**WEST SUSSEX COUNTY COUNCIL
STRATEGIC PLANNING CONSULTATION**

DATE: 9th May 2013

SUBJECT: EP/111/12 - Demolish 1 house (60 Sea Lane); partially demolish 1 house (45 The Ridings); construct 3 detached houses; alterations and extensions (45 The Ridings).

45 The Ridings, 60-62, Sea Lane, East Preston, West Sussex, BN16 2TW

SITE, BLOCK & LOCATION PLAN

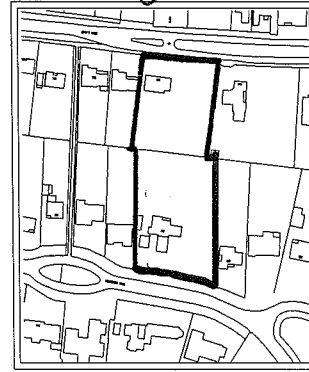
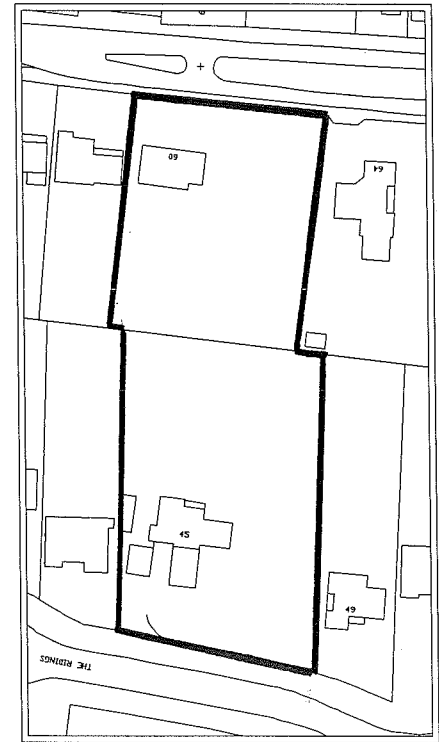
From an inspection of the plans alone the principle of the development from the Highway Authority's point of view is acceptable. However, there is an apparent shortfall in required visibility at the 4 points of access onto Sea Lane. Please submit plans demonstrating that visibility splays of 2.4m by 43m to the nearside kerb in a southerly direction can be achieved. These splays must be free of obstructions above 0.6m high, and also not cross third party land with the exception of publically maintained highway or footways. Please also include the full extent of the visibility splays.

The Ridings, which is a private road does not need to conform to these requirements.
